County of Kittitas - Proposed rezone of 58.1 acres from Ag-3 to Urban Residential with a proposed density of 19 lots. (Z-07-03 Starlite Estates.) (SEPA checklist). These materials were received on 01/09/2008 and processed with the Material ID # 12553.

Thank you for the opportunity to comment during the optional determination of nonsignificance process for the rezoning of approximately 58.1 acres from AG3 to urban residential and divide into 19 lots, proposed by Starlite Construction LLC [Z 07-03]. We have reviewed the documents and have the following comments.

In response to a KCCDS Memorandum on the Starlite Estates Rezone and Starlites Estates Plat Project
Dated January 9, 2008

LOCATED IN SECTION 26, TWN. 18N., RGE. 18E., W.M.
KITITAS COUNTY, STATE OF WASHINGTON

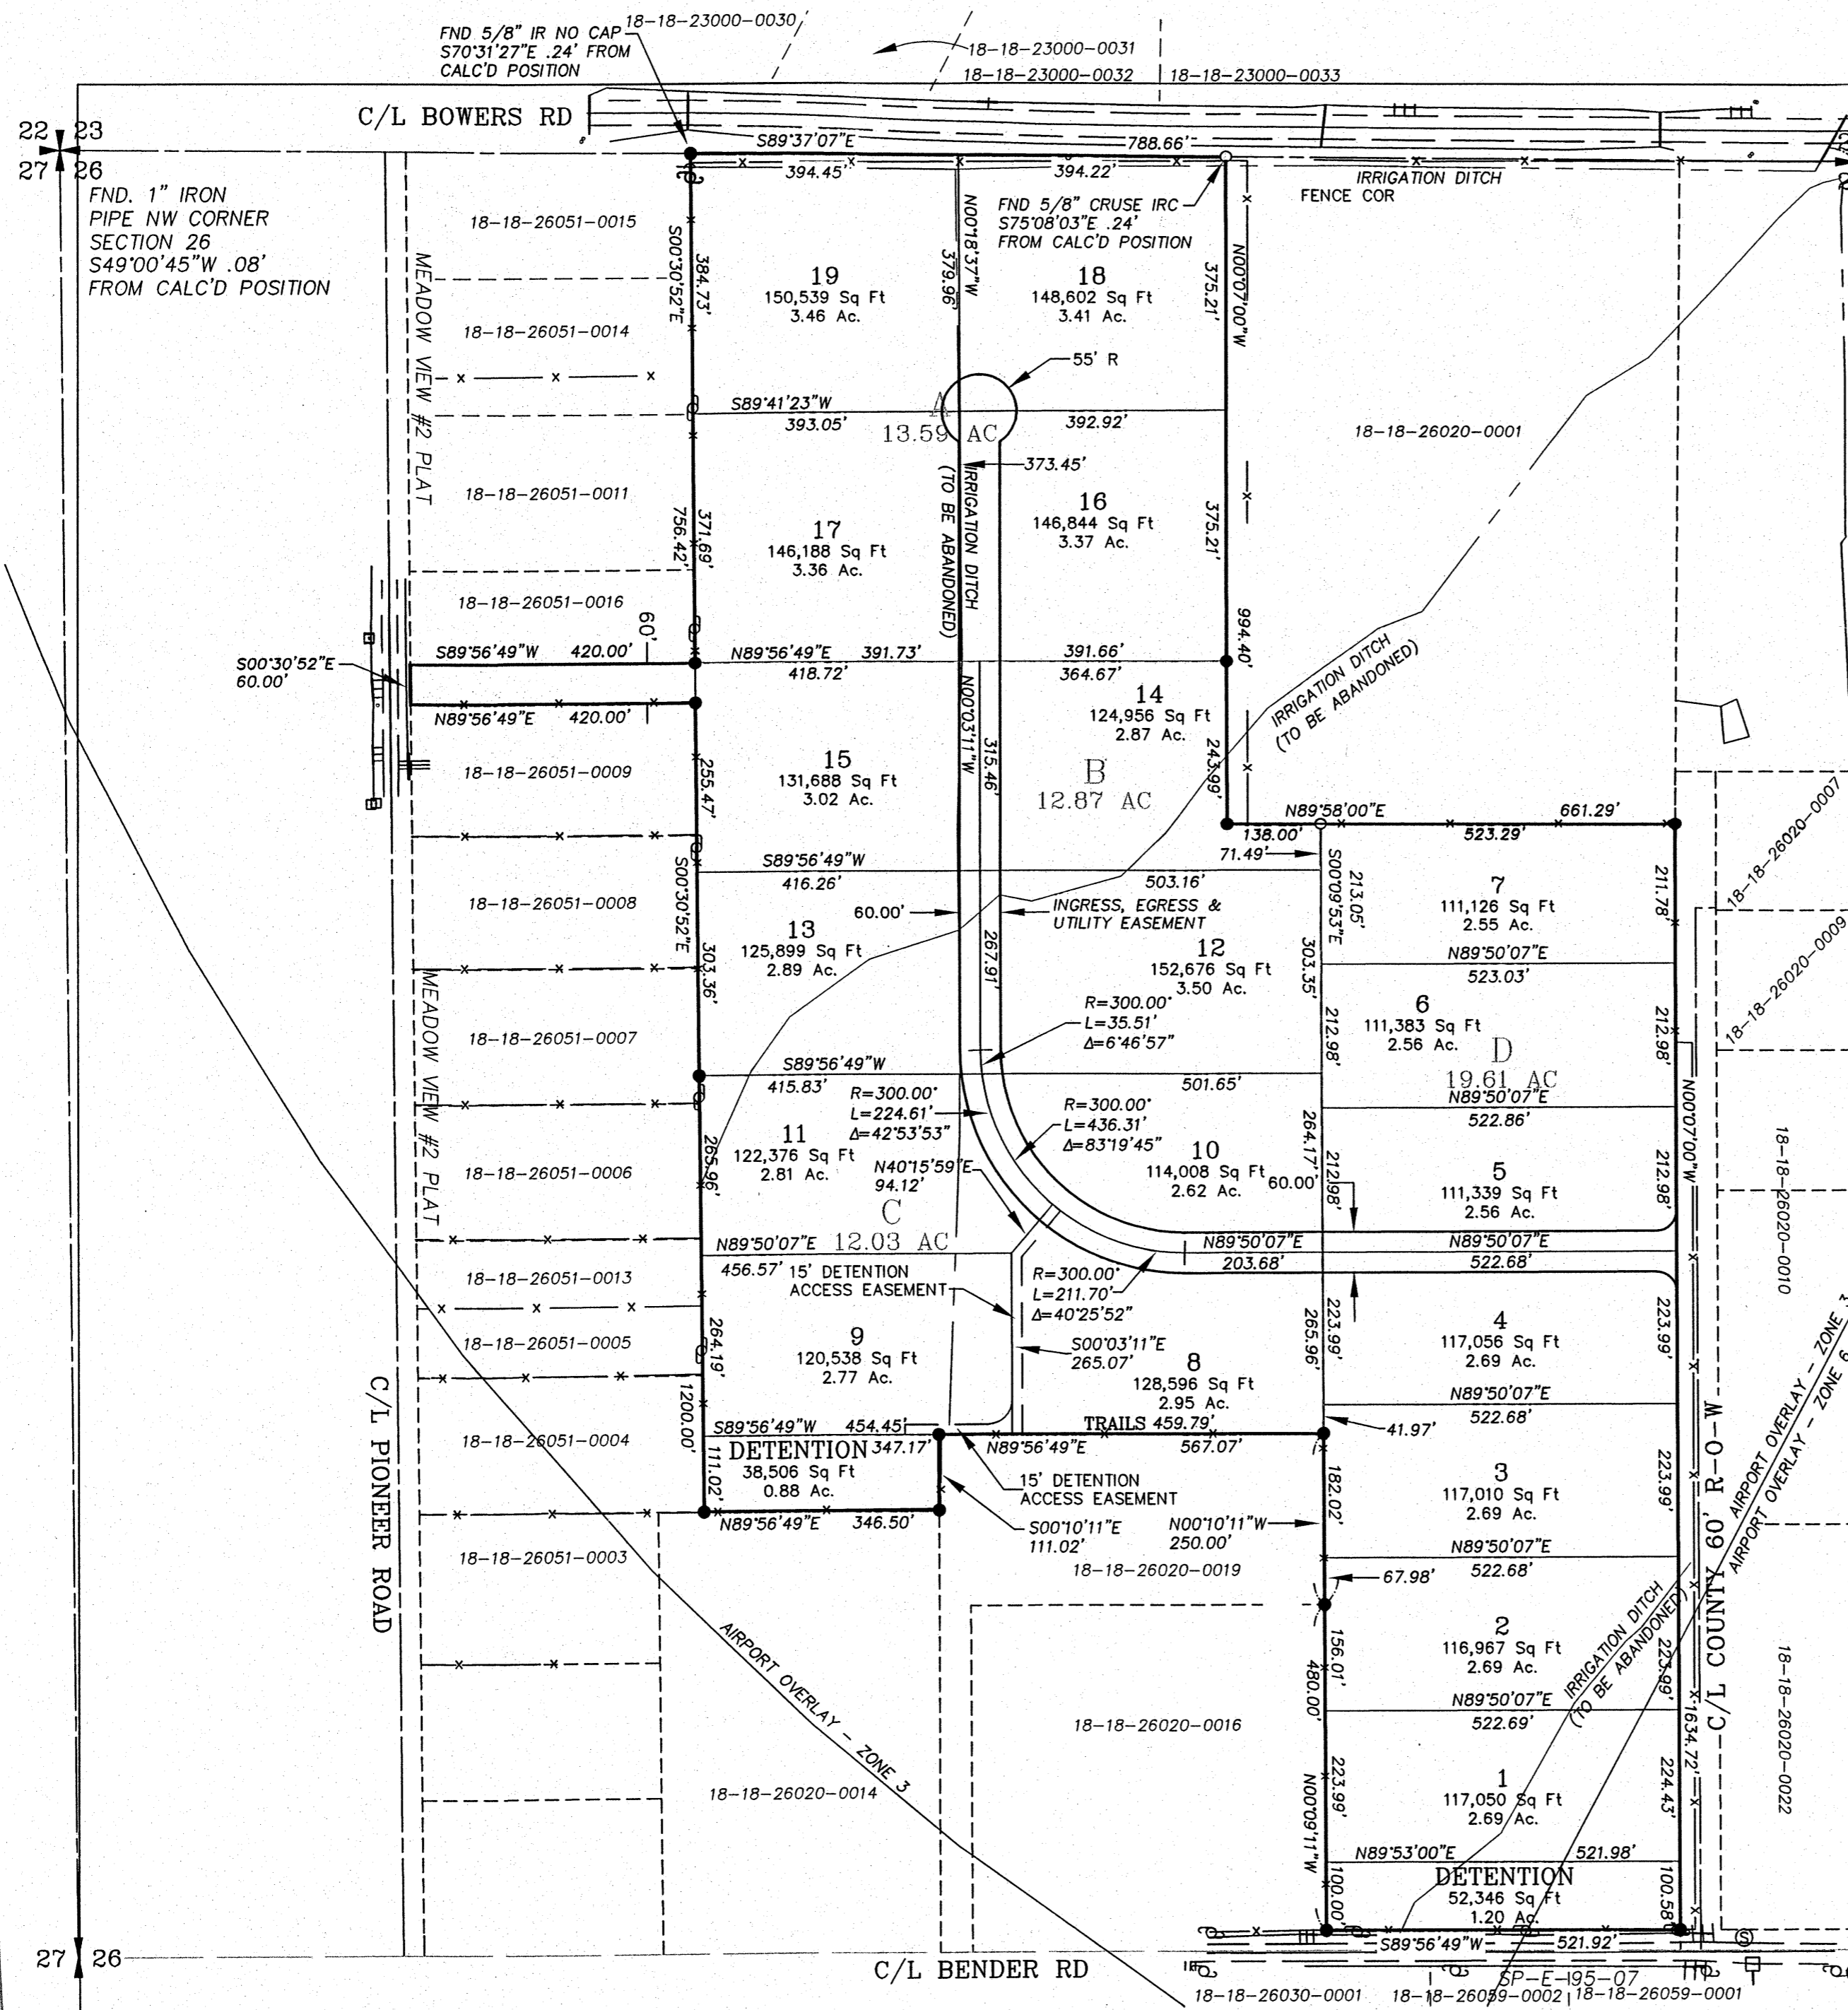
We have concerns as to the disruption of our privacy..The elimination of our view...The infest of rhodents caused by developement.. The increase in insects, frogs, snakes, brought on by the location of the drainage ponds slated to be put in right next to our yard.. What will be put in to effect to keep these ponds sprayed and cleaned up to eliminate a breeding ground for mosquitos? Will they be regularly maintained or allowed to build up with weeds ect and become an eyesore? And who will be responsible for the upkeep?

.. We also have concerns and request Starlite do a study to see how the water drain off slated to the southwest corner of this development will effect our septic system and low spots on our property..

Because of the encroachment of our property on 3 sides by this development we are requesting an 8 foot berm be built on these 3 sides ..with a chain link fence on top and fully planted with trees shrubs ect and landscaped.. This would allow us to maintain some privicy and muffle some of the noise factors stated above..
